CITY OF ALBUQUERQUE

January 5, 2022

Re: EL Encuentro Immigrant Community Center
907 4th Street SW
Traffic Circulation Layout (TCL)
Architect's Stamp 10-15-2021 (K14-D121)

PROPOSED PARKING & TRAFFIC CIRCULATION LAYOUT
PROPERTY LOT A & B
SCALE 1"= 20'

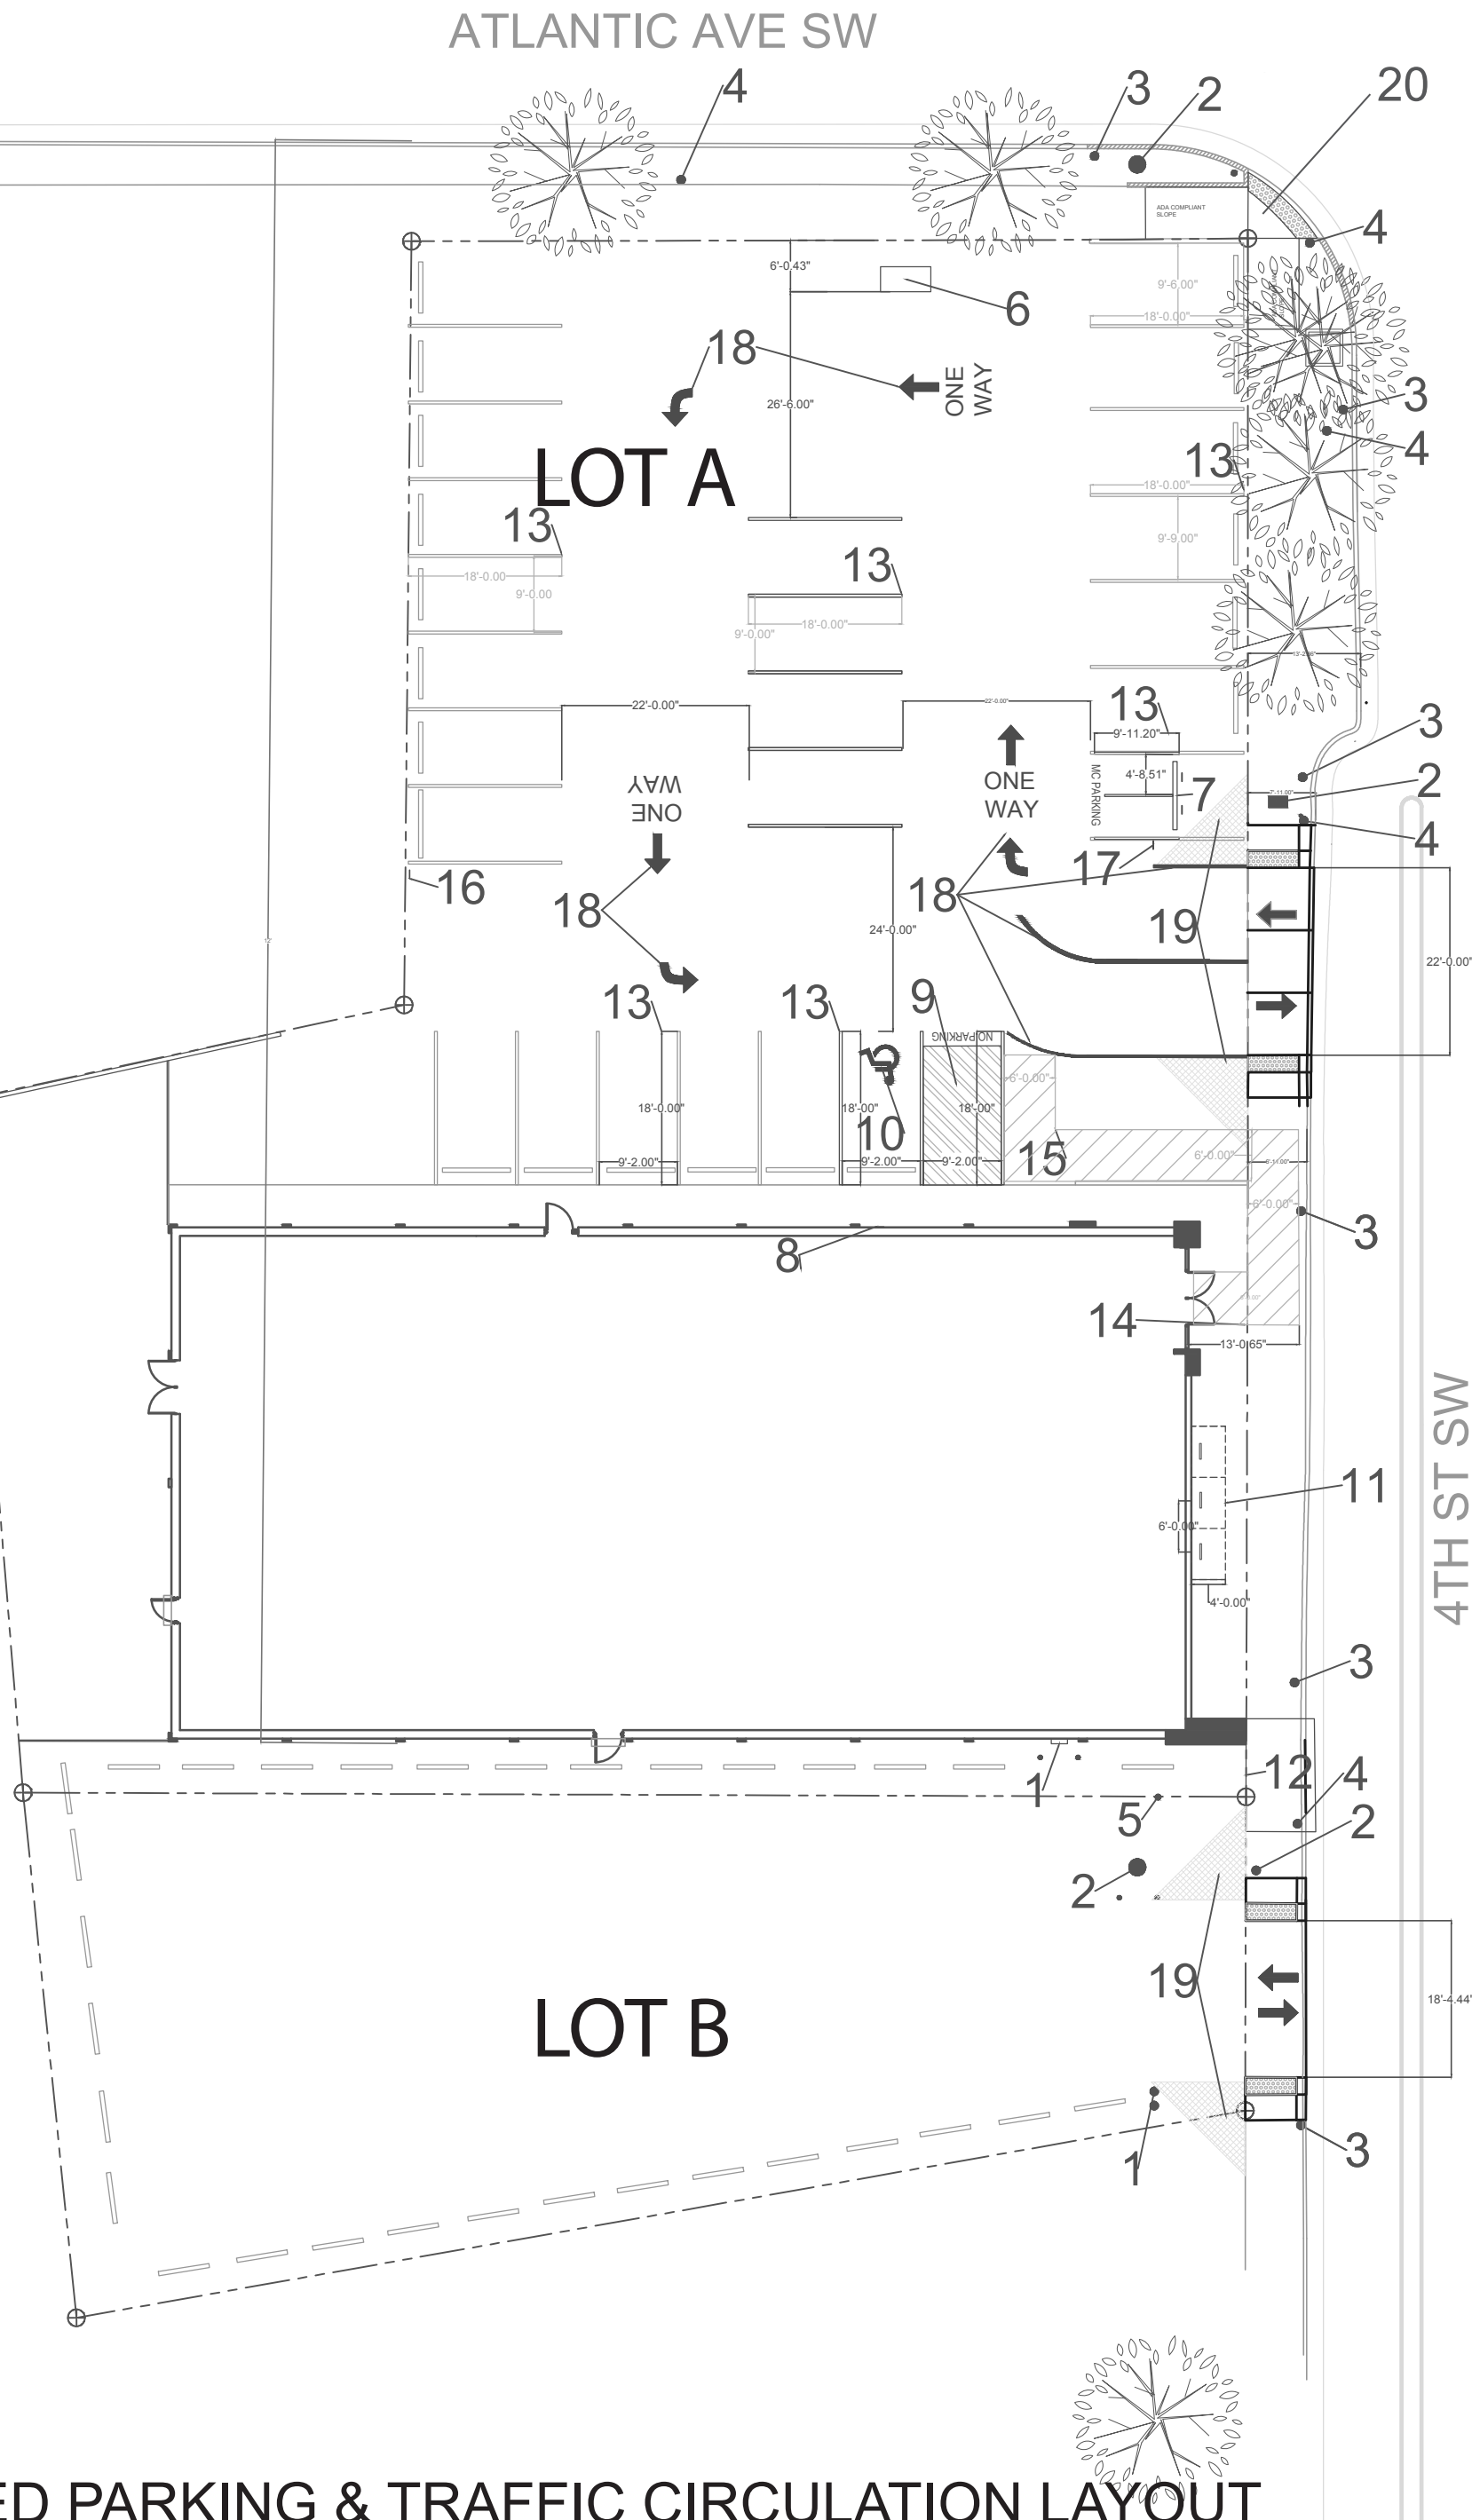
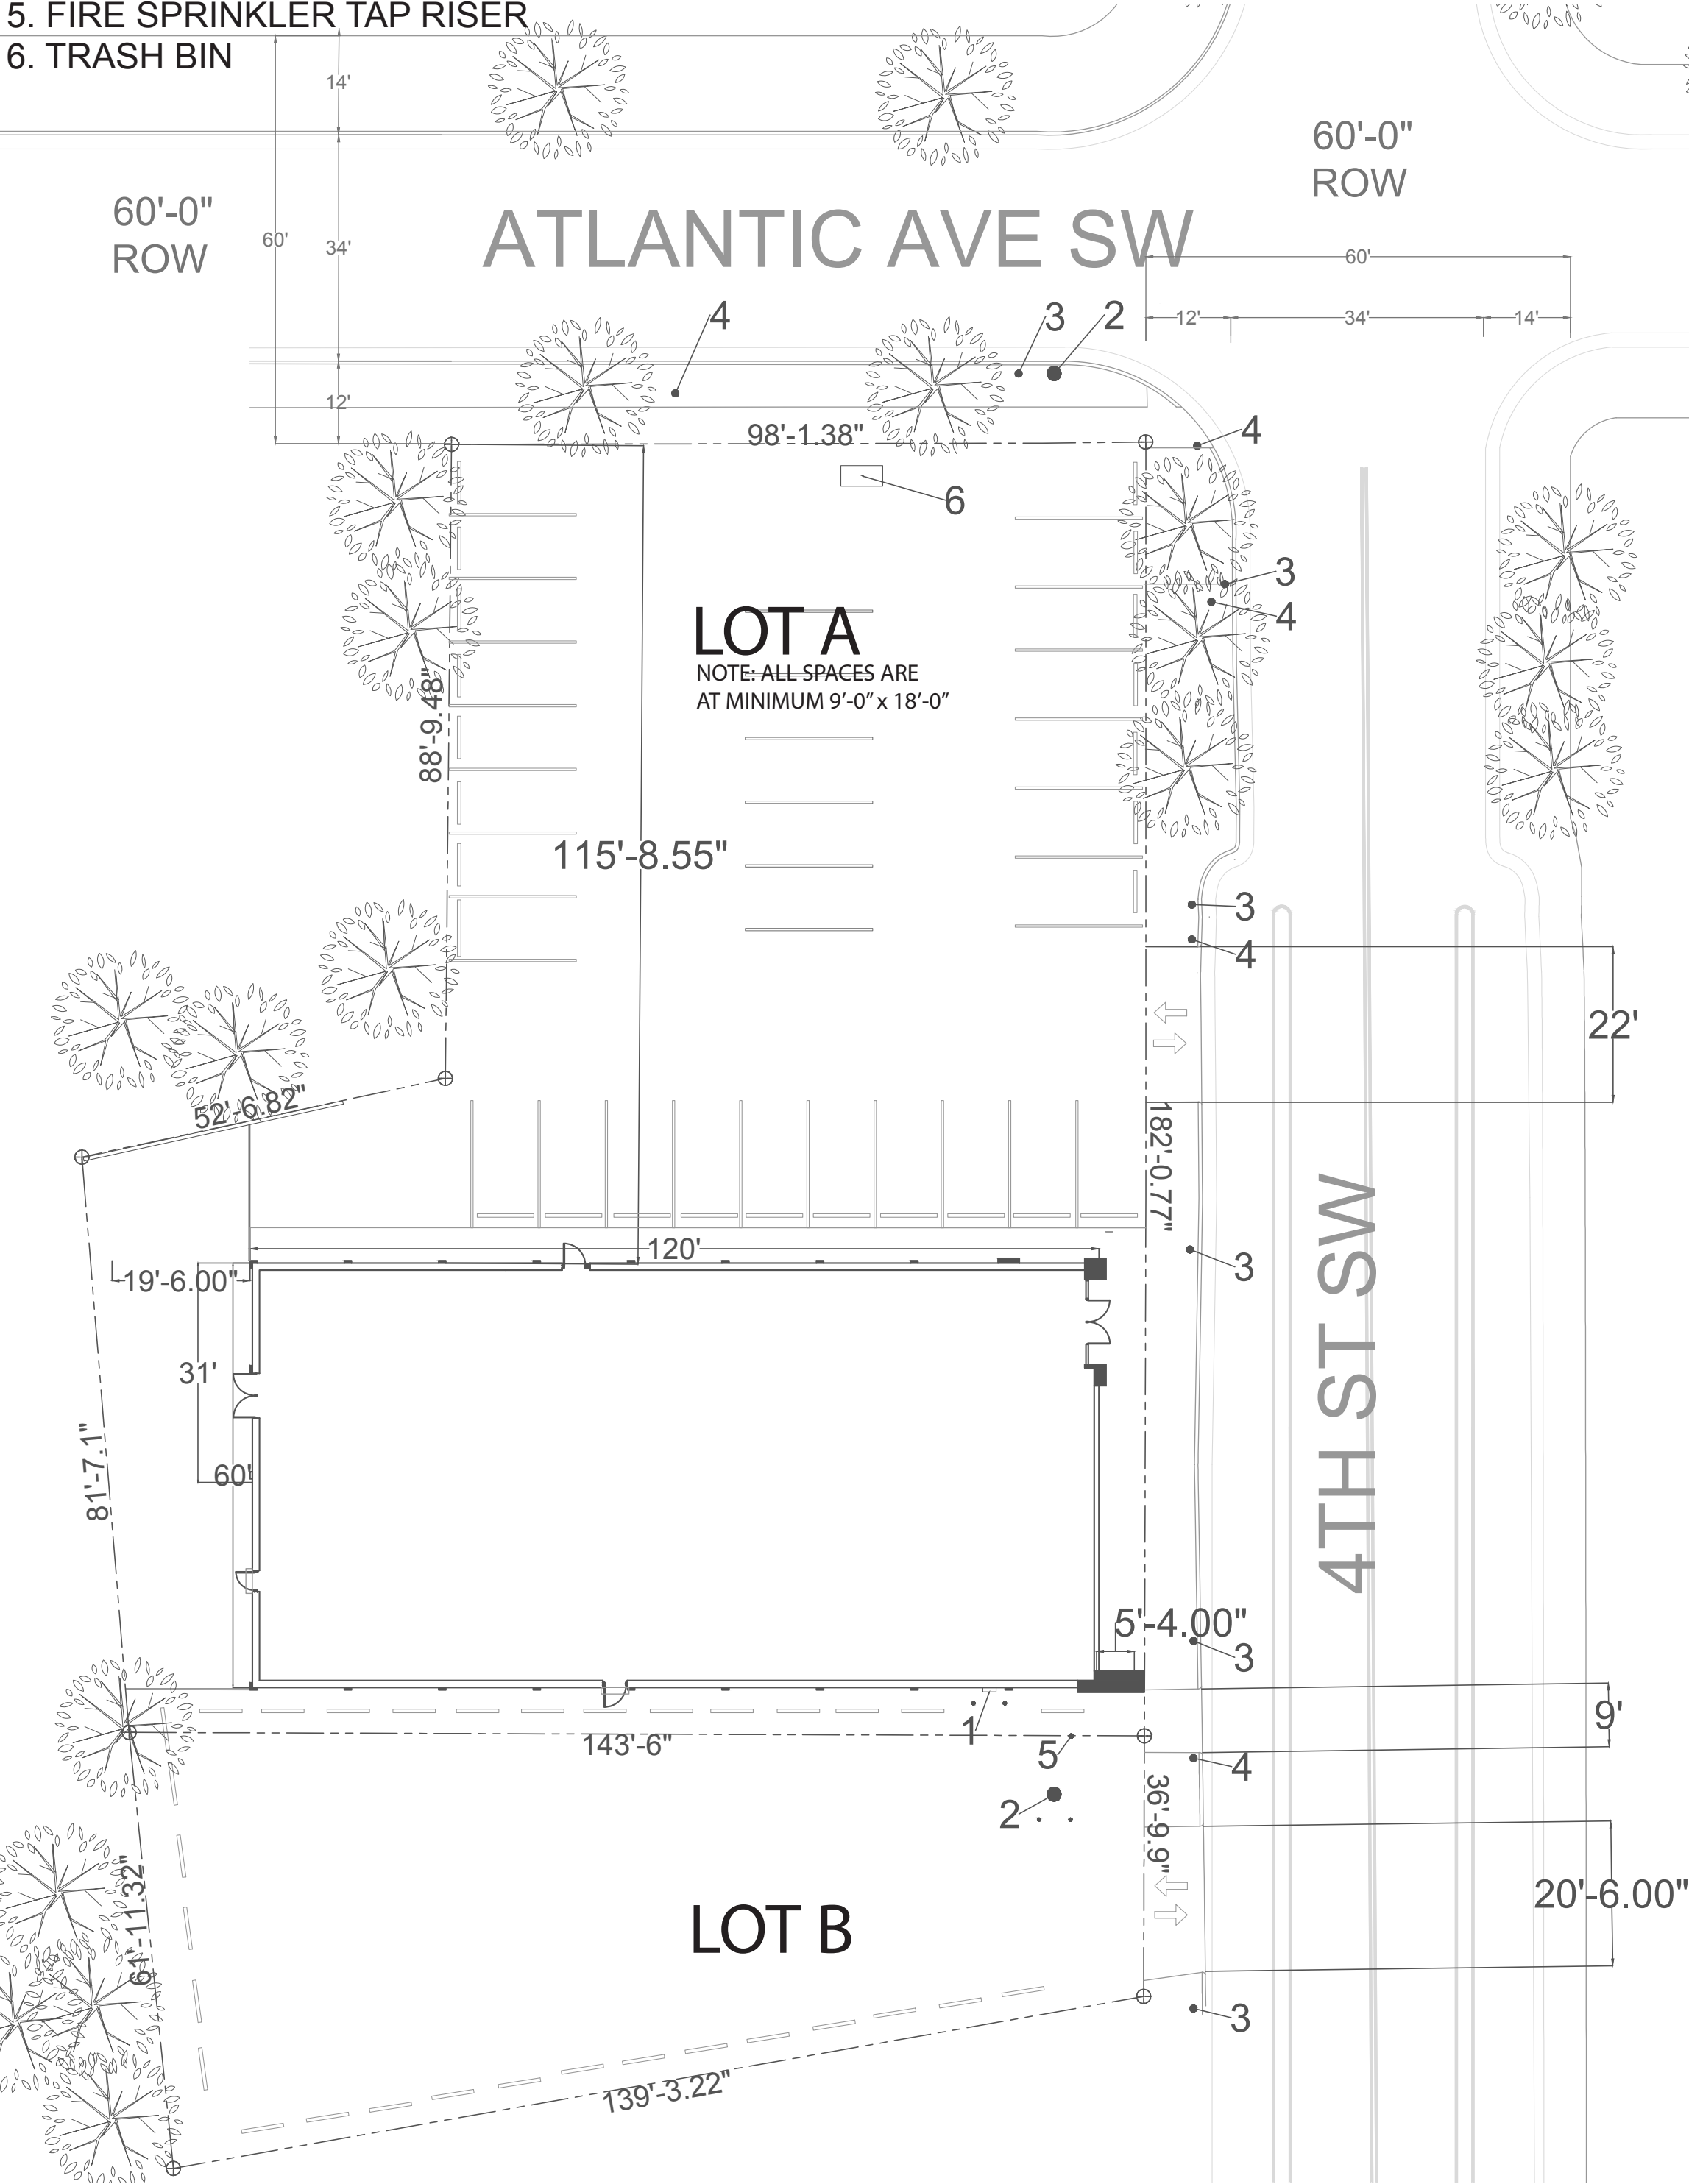
2. Legend Note 12: You will need to reference COA std dwg 2415(standard c&g) and COA std dwg 2430 (sidewalk).

3. The scale must be shown on the plan. Per the Development Process Manual, Chapter 27, Section 2, Part B.1, on the following scales may be used:

- Select a scale above that can be used for your TCL project design.**

4. The minimum parking stall dimensions are:

Type of parking	Min. Width	Min. Length	Min. Overhang
Standard	8.5'	18'	2'
Compact	7.5'	15'	1.5'
Motorcycle	4'	8'	N/A

ADA	8.5'	18'	2'
-----	------	-----	----

- **The ADA parking stall and access aisle are not dimensioned . Please provide dimension to assure requirements are met.**

5. The ADA accessible spaces must include an access aisle. Van accessible aisles should be **8ft wide**; all others should be 5ft wide.
6. The ADA accessible parking sign must have the required language per 66-7-352.4C NMSA 1978 **"Violators Are Subject to a Fine and/or Towing."** Please call out detail and location of signs. **This detail will need to be provide on the TCL site plan.**

7. The ADA access aisles shall have the words **"NO PARKING"** in capital letters, each of which shall be at least one foot high and at least two inches wide, placed at the rear of the parking space so as to be close to where an adjacent vehicle's rear tire would be placed. (66-1-4.1.B NMSA 1978). Provide detail for access aisle striping, symbol, and sign face detail. **Provide letter detail for NO PARKING, since there are not details provided on site plan.**

11. Per DPM, a 6 ft. wide ADA accessible pedestrian pathway is required from the ADA parking stall access aisles to the building entrances. Please clearly show this pathway and provide details.

12. **Legend Note 15:** ADA accessible pedestrian pathway **SHOULD NOT** be placed behind parking space or adjacent to a vehicular way. Vehicle and pedestrian/wheel chair conflicts should be avoided as much as possible.

13. All one-way drives shall have "One Way" and "Do Not Enter" signage and pavement markings: Please show/provide **details** for sign face and pavement markings.; need pavement marking (Do Not Enter) at end of drive aisle; the proposed sign (legend note 16) is a safety hazard for vehicular traffic.
